Environmental Impact Statement – The Northern Road Upgrade (SSI 7127)

WaterNSW has reviewed the EIS (Jacobs Australia for RMS; June 2017), and makes the following comments:

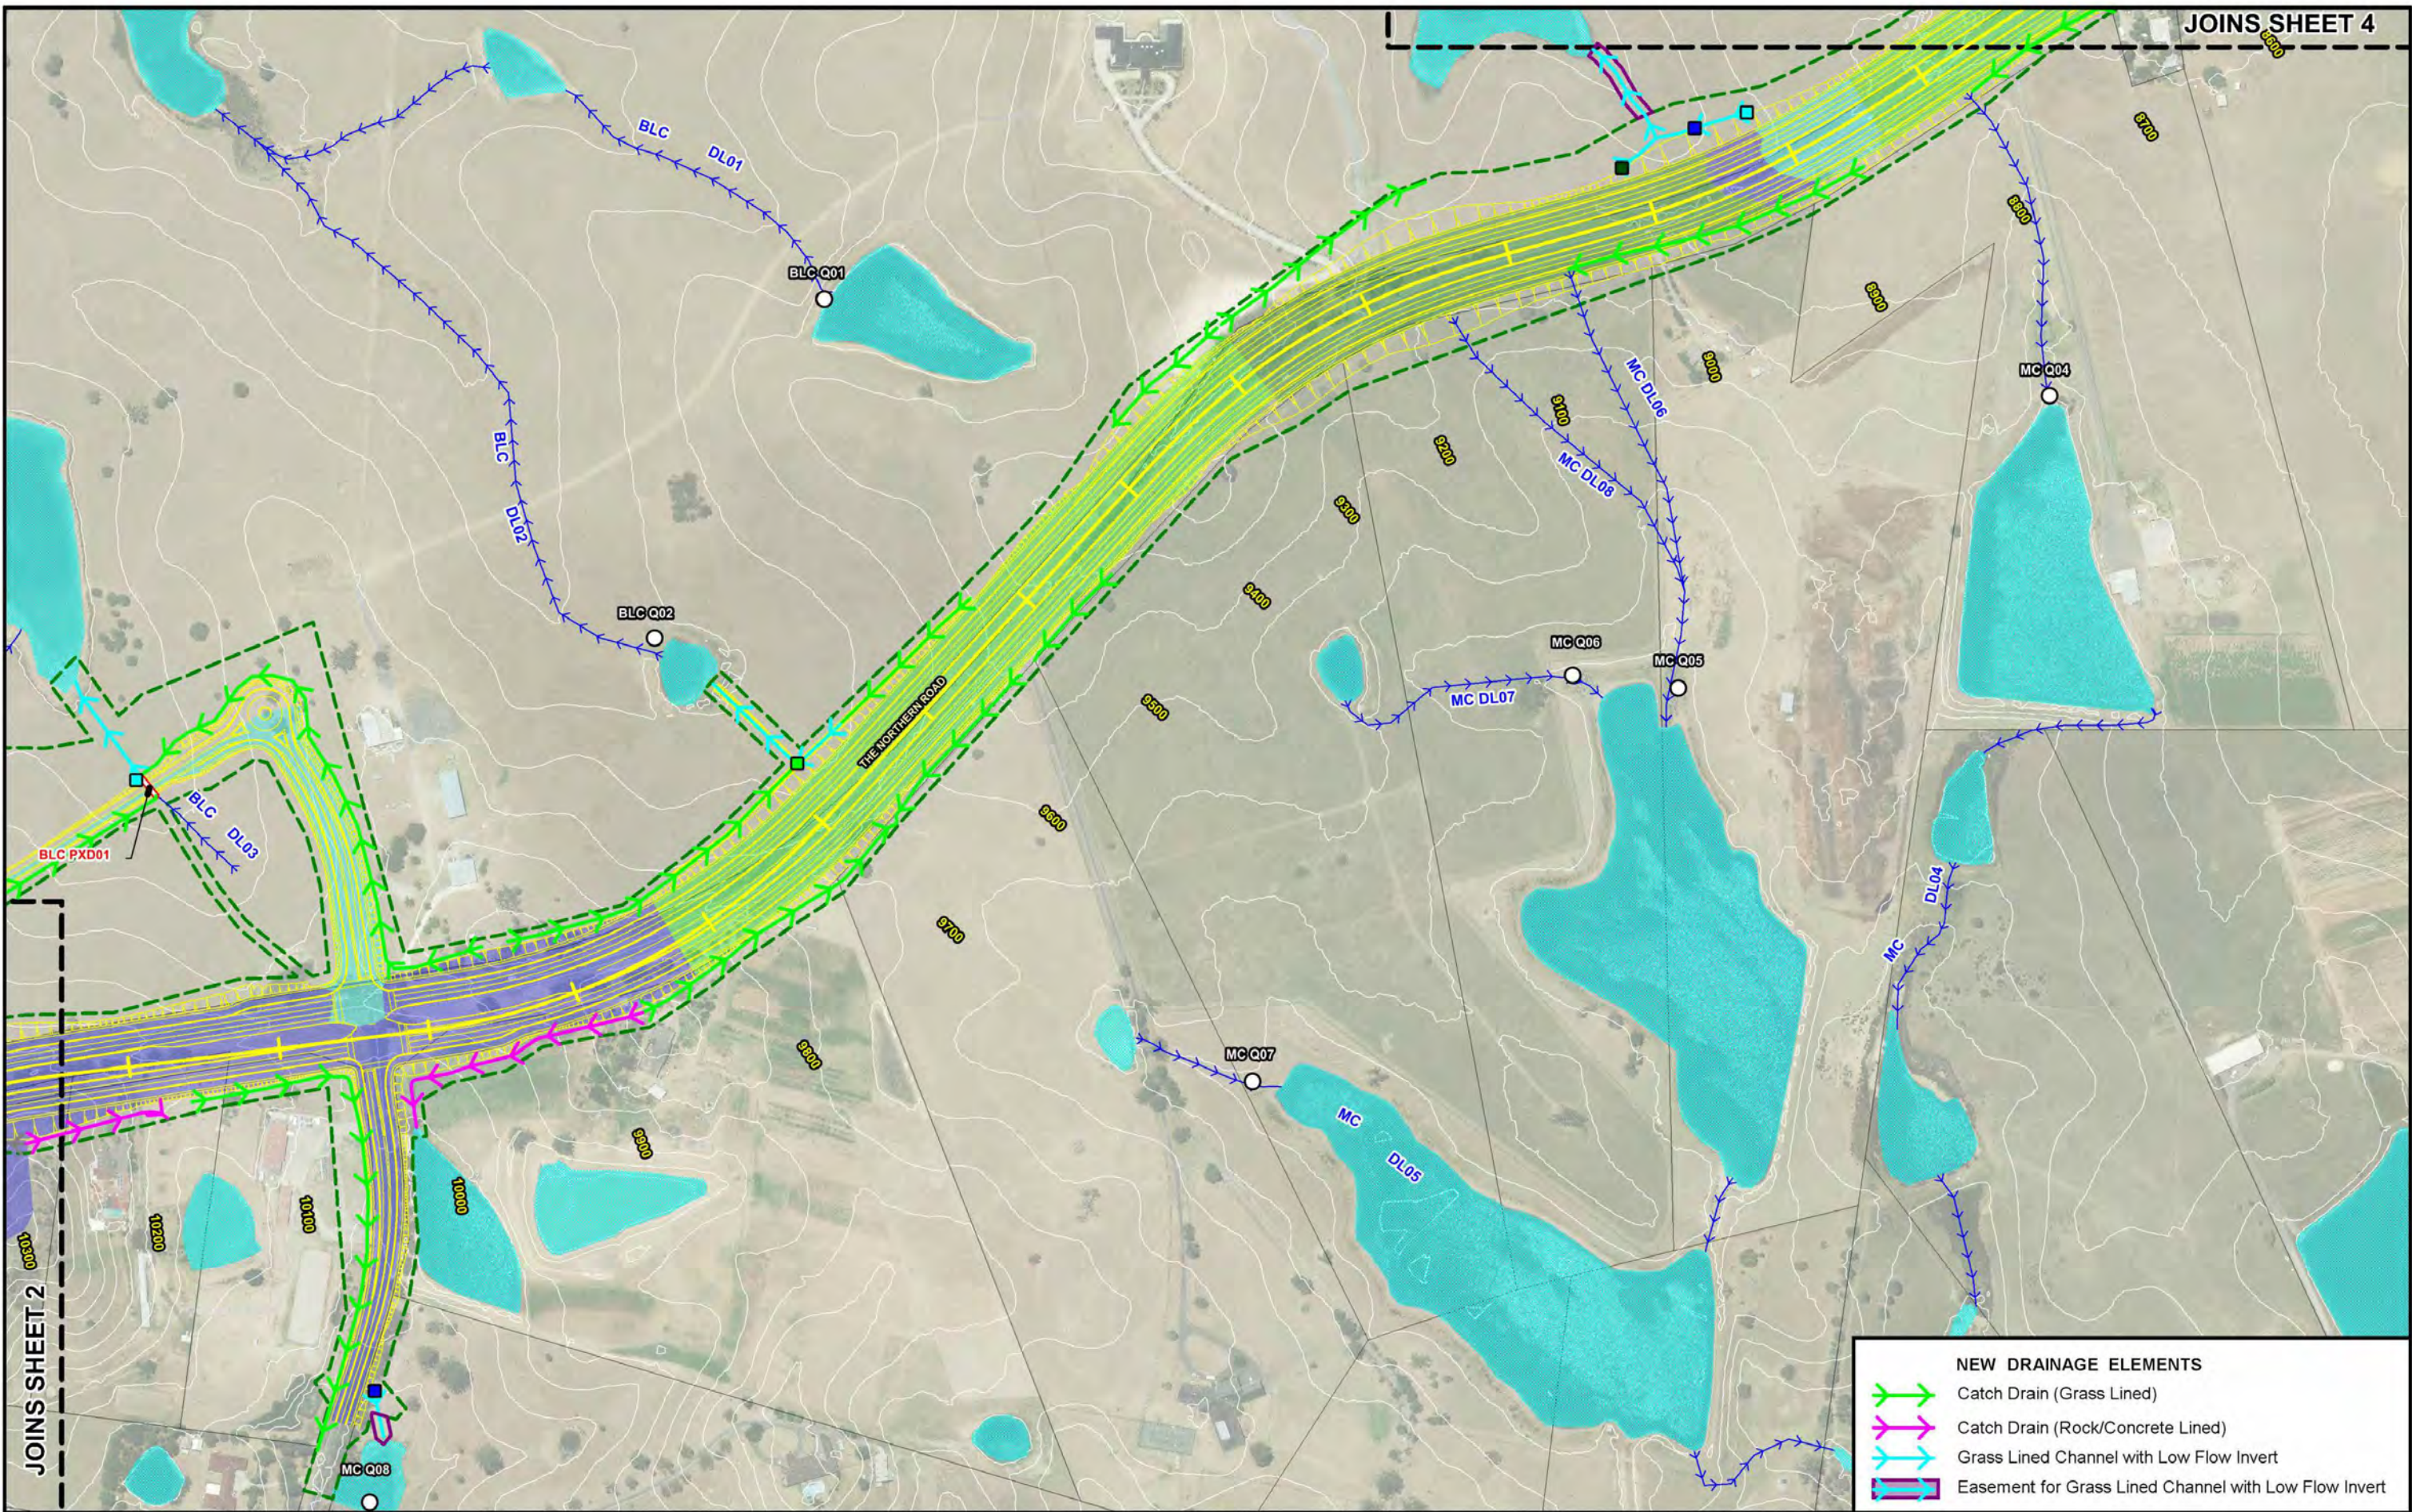
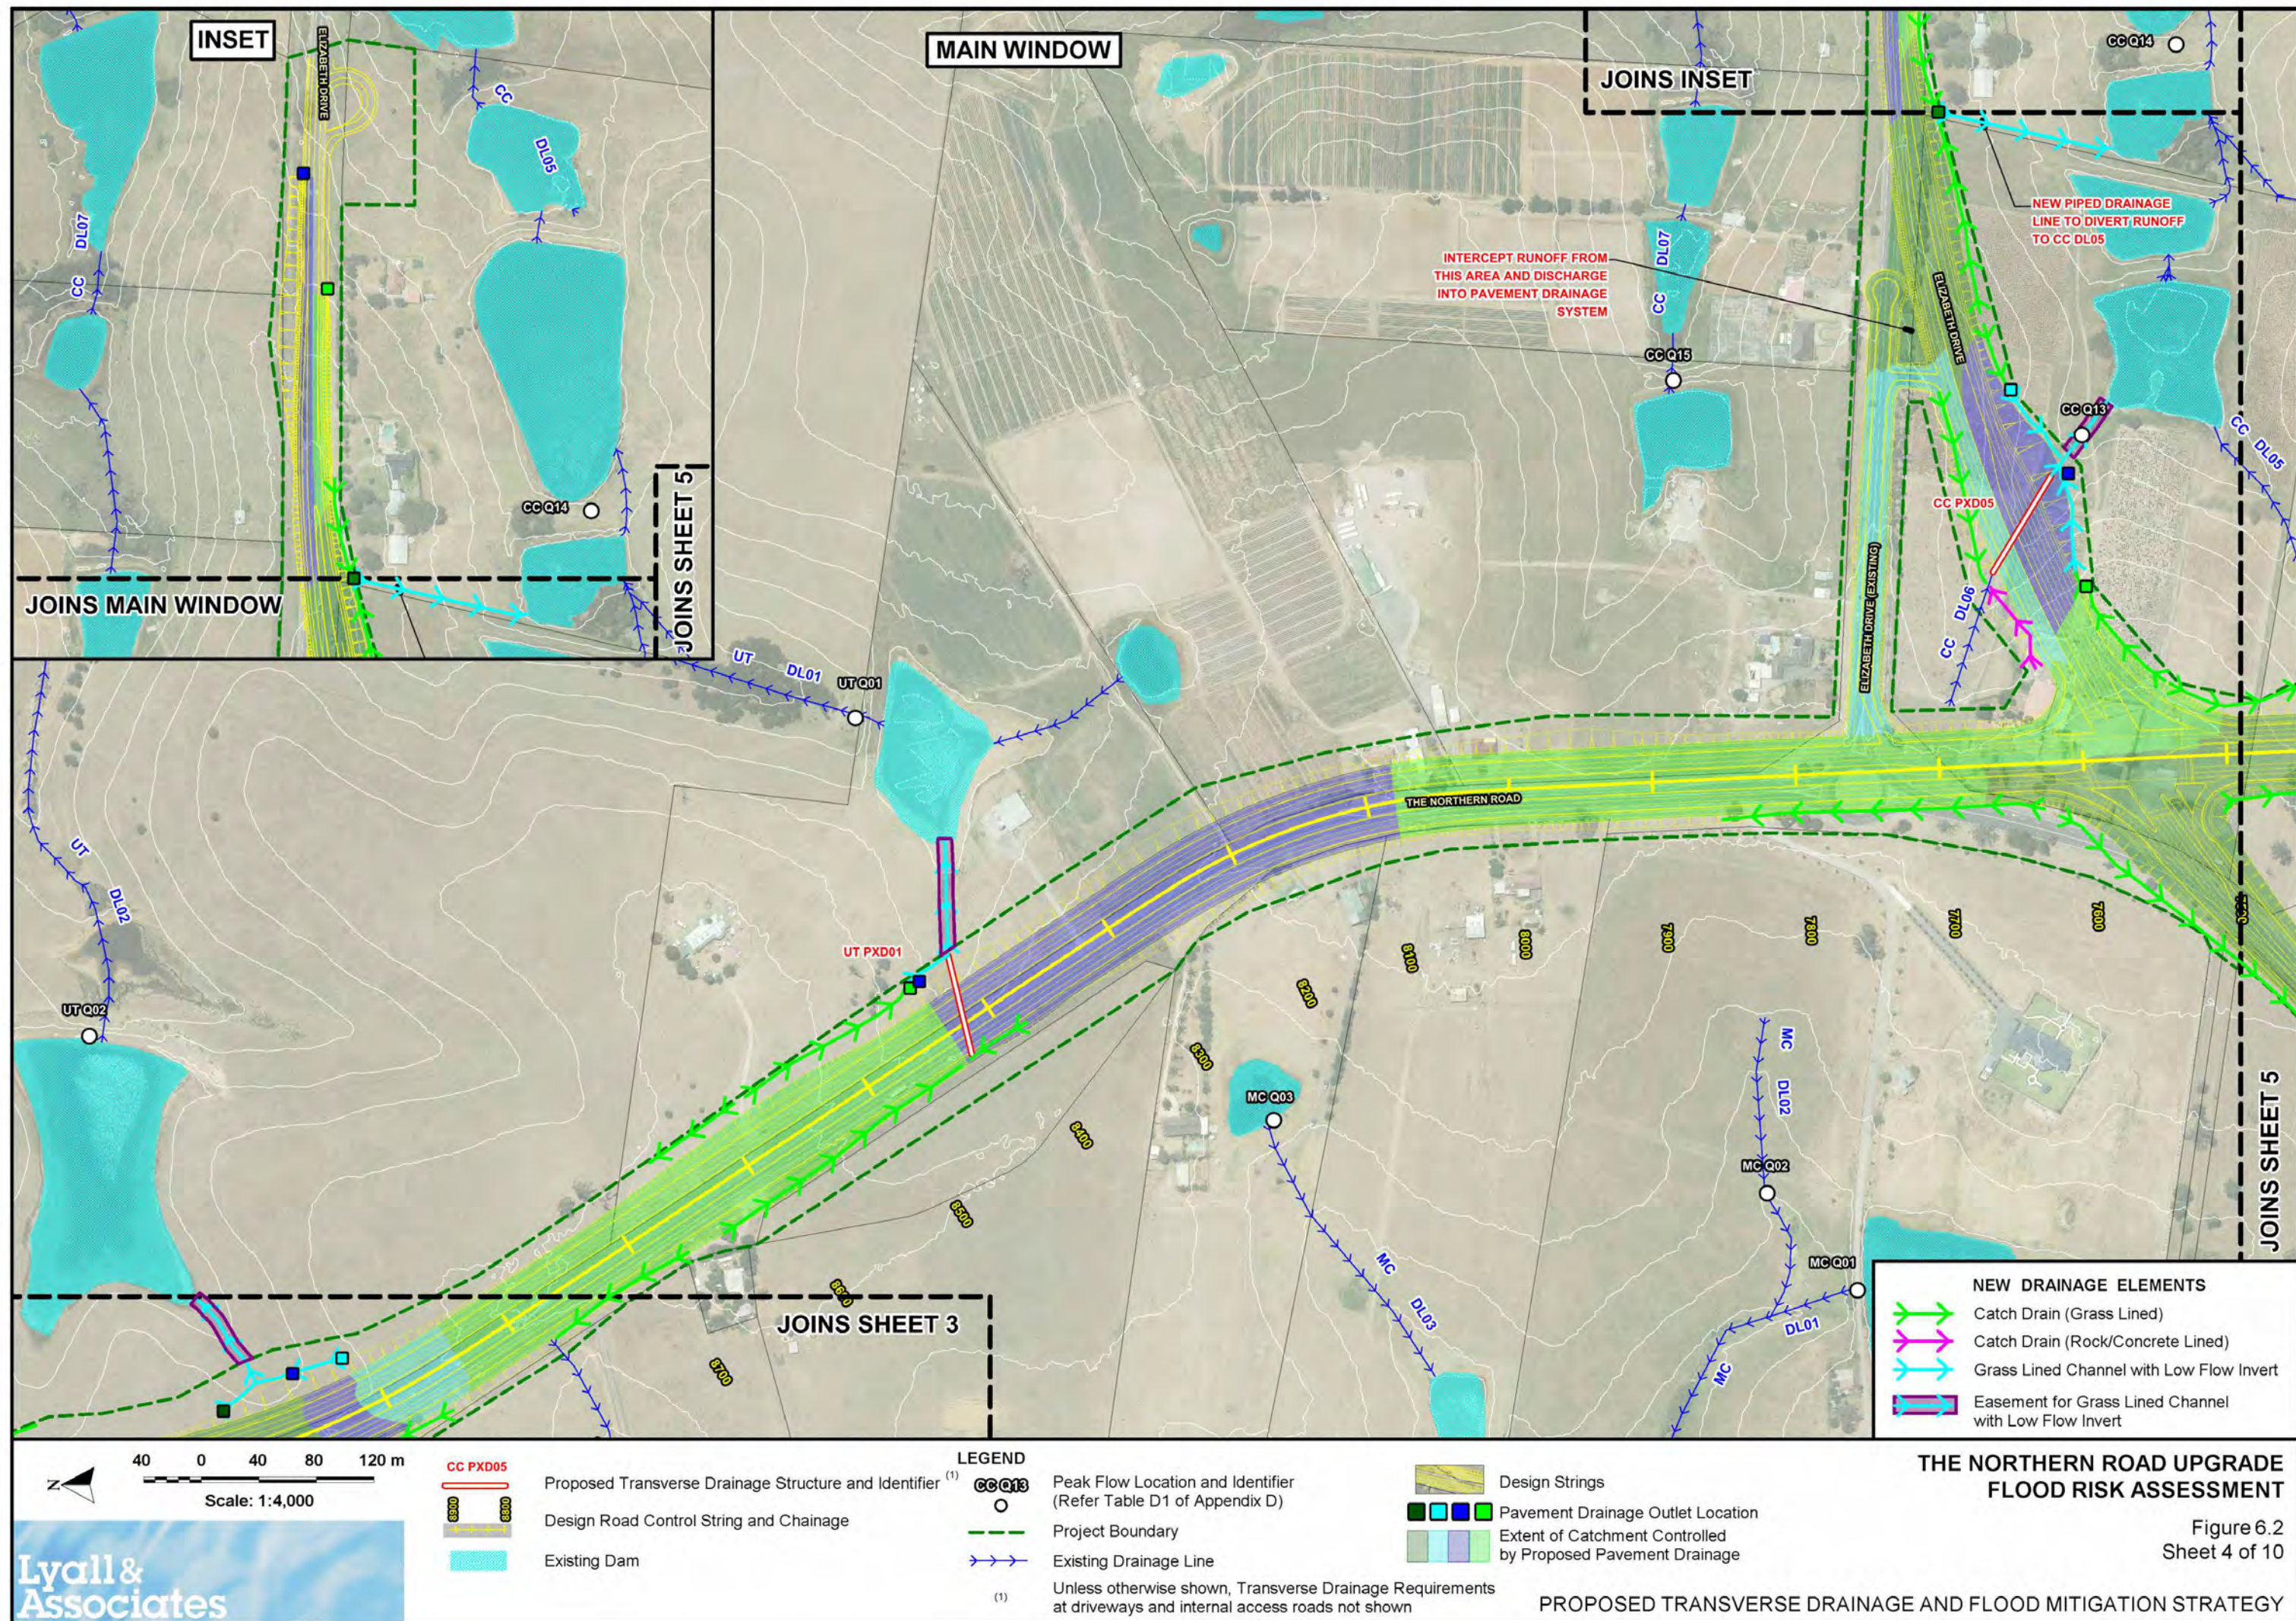
WaterNSW requires that there is no increase in stormwater flows into the Pipelines corridor over the pre-development state. While it is WaterNSW's preference that any additional runoff or increase in peak flow hydrographs (for any storm) due to the increase in impervious area due to road widening be drained away from the WaterNSW corridor, WaterNSW supports the proposal for the provision of a new pipes trunk drainage line conveying the runoff to discharge to drainage line BLC DL06 via and armoured spreader on DEOH land, as identified on Figure

6.2 Sheet 2 of Appendix K, and in Vol.1 of the EIS (s5.2.7; Table 5-5; p.107). The headwall is to be located on DEOH land, and not within the WaterNSW boundary.

- into drainage line BLC DL03 from the works in the vicinity of Gates Road on Lot 23 DP 207317 (Appendix K; Figure 6.2; Sheet 2)
 - the diversion of flow from a section of the new six-lane road west along Littlefields Road where it would discharge to an existing dam located on the southern side of the road adjacent to the limit of works, which flows into the Pipeline corridor further west (Appendix K; Figure 6.1; Sheet 1).
